Your Reference: SSD 8643  
Our Reference: OUT18/3159

**Re: Sapphire Solar Farm (SSD 8643) – Environmental Impact Statement  
Exhibition**

Thank you for the opportunity to provide advice on the subject proposal. This is a response from NSW Department of Planning & Environment – Division of Resources & Geoscience, Geological Survey of New South Wales (GSNSW).

Figure 7-7: Current mining and exploration leases and applications in the Project Outline and immediate surrounds. Source: NSW Department of Industries (2016a) and NSW Department of Industries (2016b)

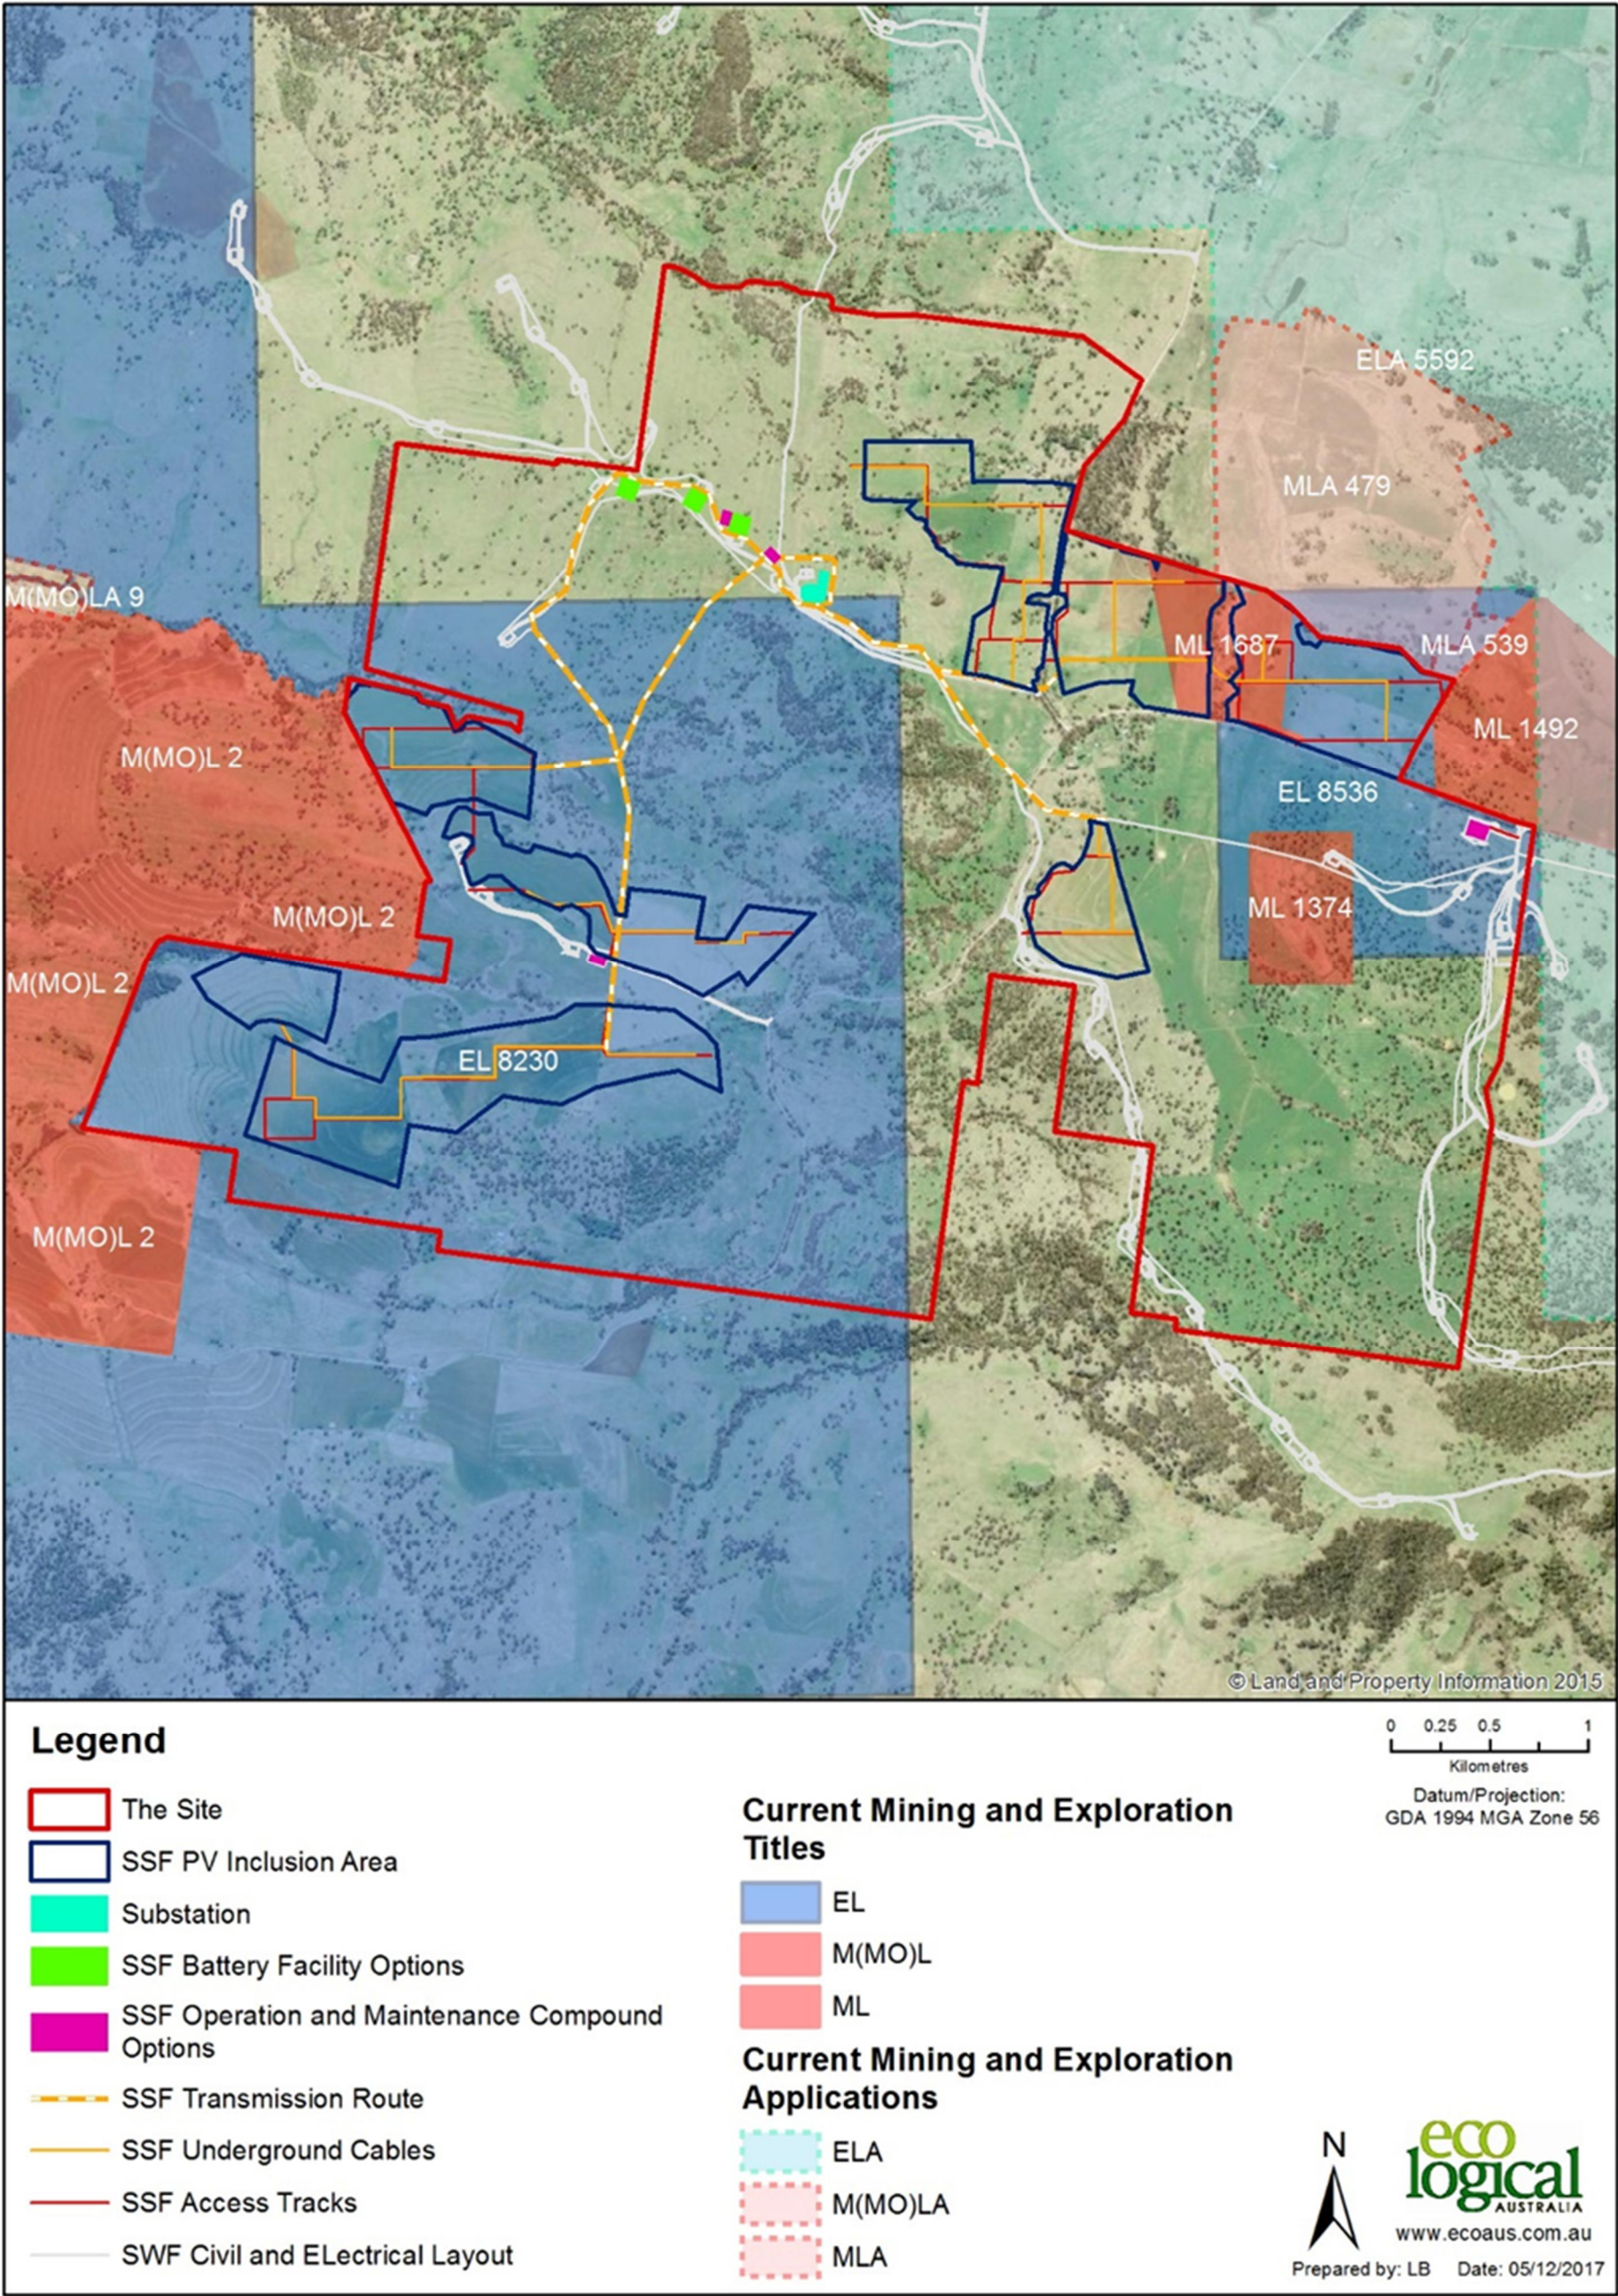
GSNSW acknowledges that the proponent has addressed land use in relation to mining, exploration and minerals in the EIS, reviewed the DRG online MinView and Common Ground Viewer, and identified exploration and mining titles and applications in the vicinity of the Project site (Refer to page 119 of the EIS) on a map. The proponent has provided GSNSW directly with evidence of consultation with the adjacent and impacted titleholders to the project area. GSNSW notes that Coordination Deeds between the parties are in the process of being drafted (Refer page 6 of the EIS).

A proposed Biobanking Agreement Application has been submitted to OEH (Refer to page 102 of the EIS and page 52 of Appendix B) at Windemere, Kings Plains. An Exploration Licence Application (ELA5592 identified on Figure 7-7 page 120 of the EIS) sits over this area. GSNSW has concerns relating to the biobanking application and resource sterilisation. This area is prospective for sapphires and the proposed biodiversity offset area may adversely affect explorers for potential resources. GSNSW requests to be consulted in relation

to the proposed location of any biodiversity offset areas or any supplementary biodiversity offset measures to ensure there is no consequent reduction in access to prospective land for mineral exploration, or potential for sterilisation of mineral resources.
